# **SSD 6633 - SICEEP Darling Square - Mixed Use Residential Building within the South-East Plot**

# SSD 6633 Submission

FACADE SYSTEMS

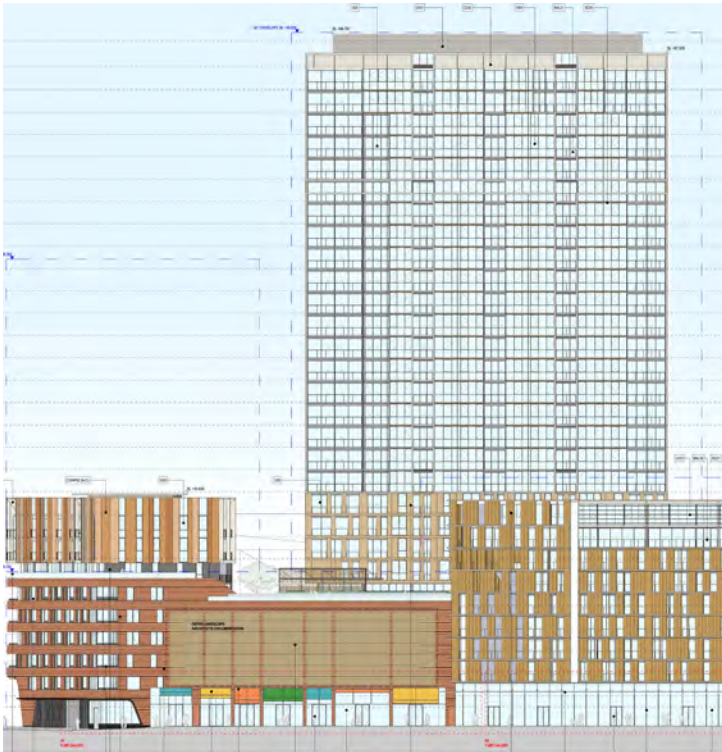
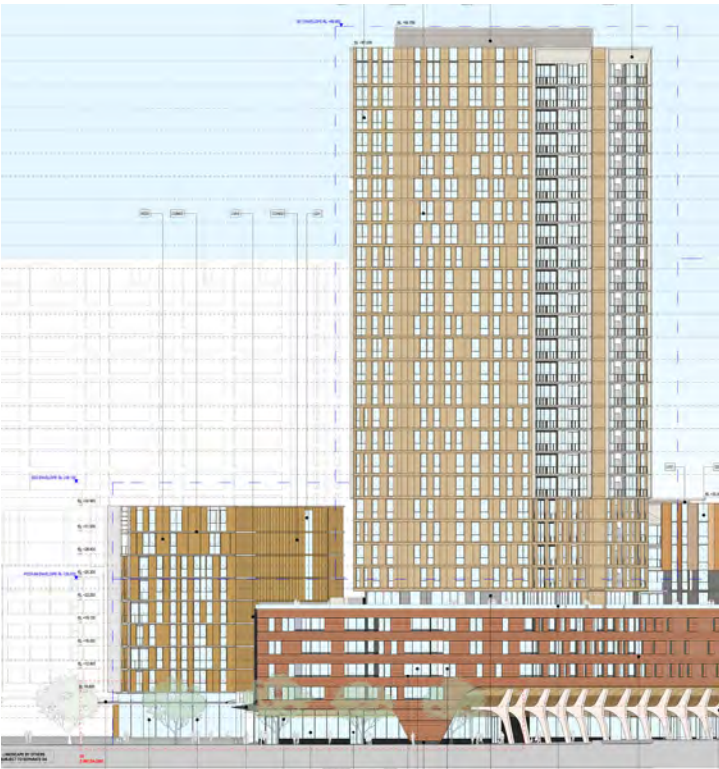
<p>EIS 3.4.2 page 37. Figure 21, building SE1 southern elevation</p> <p>There is no brise soleil.</p> <p>Appendix B Design Report 07A, p64</p> <p>Façade system diagram, building SE1 southern elevation</p> <p>There is a brise soleil.</p>	<p>The two documents are contradictory.</p> <p>The proponent has rushed this document and is still undecided about the materials and finishes.</p>
<p>On all facades of SE1, there is no use of any bright colours.</p>	<p>The proponent is overwhelmed by the task of designing a large residential building which is also attractive. The SE1 building appears to be commercial or institutional rather than residential.</p>
<p>EIS 3.4.2 page 42</p> <p>"The façade of Building SE3 is composed of a geometric collage blending autumnal tones to create a finely scaled screen of warm hues. "</p>	<p>The proponent is unwilling or unable to apply the genuine colour creativity which it displays in the small building SE3 in the much larger building SE1.</p>
